Department of Transportation

Traffic & Safety – Permits Unit

RE: North Tree at Calhan

We are in receipt of a referral request for comments regarding the Traffic Impact Study (TIS) for North Tree at Calhan dated June 17, 2024. The development is anticipated to include 473 single-family detached residences and is located north of Calhan off US Highway 024G via Crystola Street. After review of the submitted TIS, we have the following comments:

FIGURE 2
NORTH TREE RESIDENTIAL
CALHAN, COLORADO
EXISTING GEOMETRY AND CONTROL

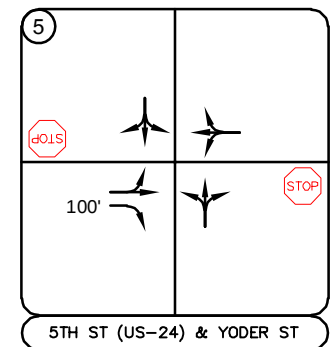
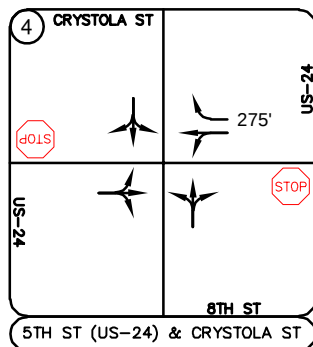
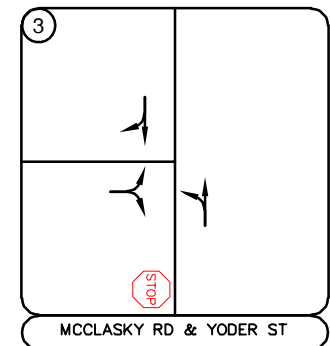
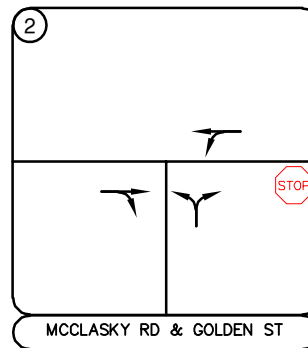
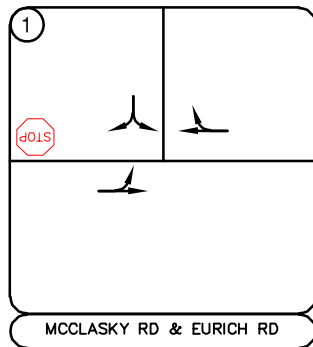
- The existing intersection also accommodates the East/West roadway, 8th Street, and is essentially a five-point intersection. The added traffic to this current configuration will cause significant safety and operational issues. The project will need to recommend an intersection solution that addresses the traffic volumes and roadway intersecting with US24.
- Minimum improvements required to be made to US24 (5th Street) and Crystola are:
 - o Eastbound left turn deceleration lane
 - o Westbound right turn deceleration lane
 - o Southbound right turn deceleration lane

FIGURE 10
NORTH TREE RESIDENTIAL
CALHAN, COLORADO
RECOMMENDED GEOMETRY AND CONTROL

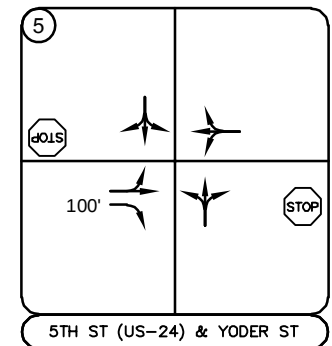
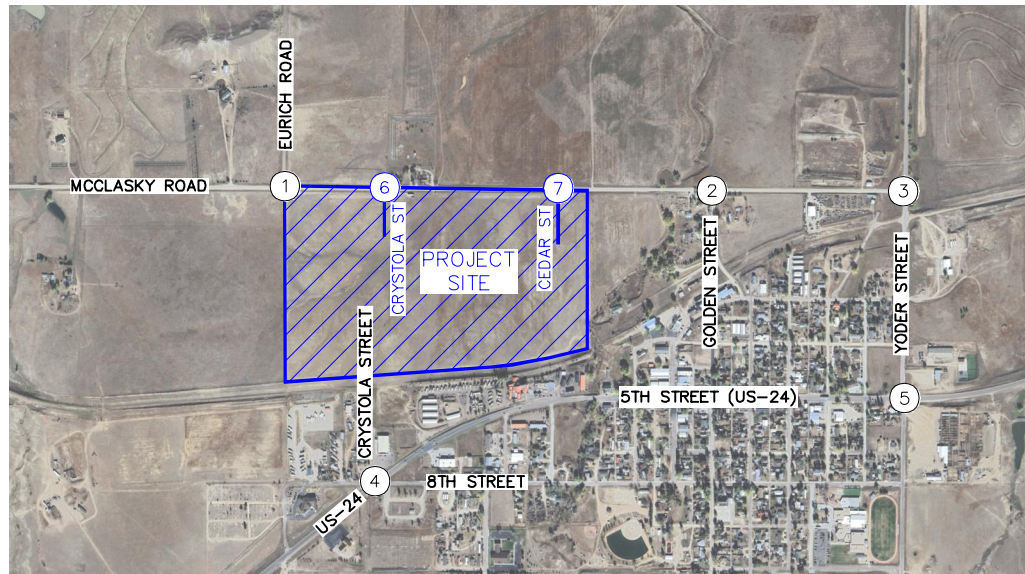
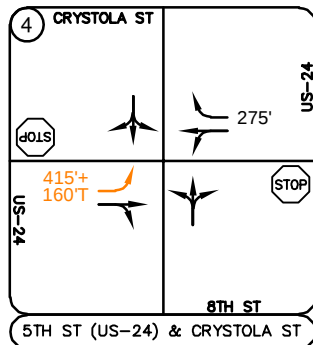
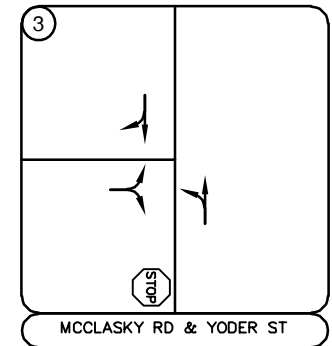
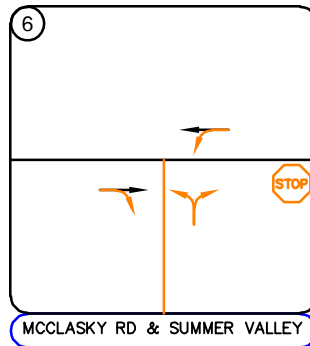
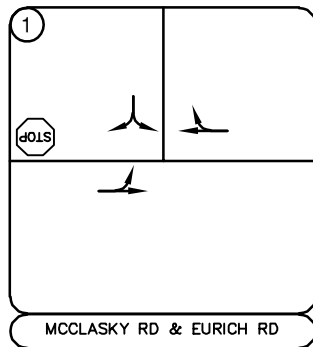
Address the traffic comments above and resubmit documents as necessary.
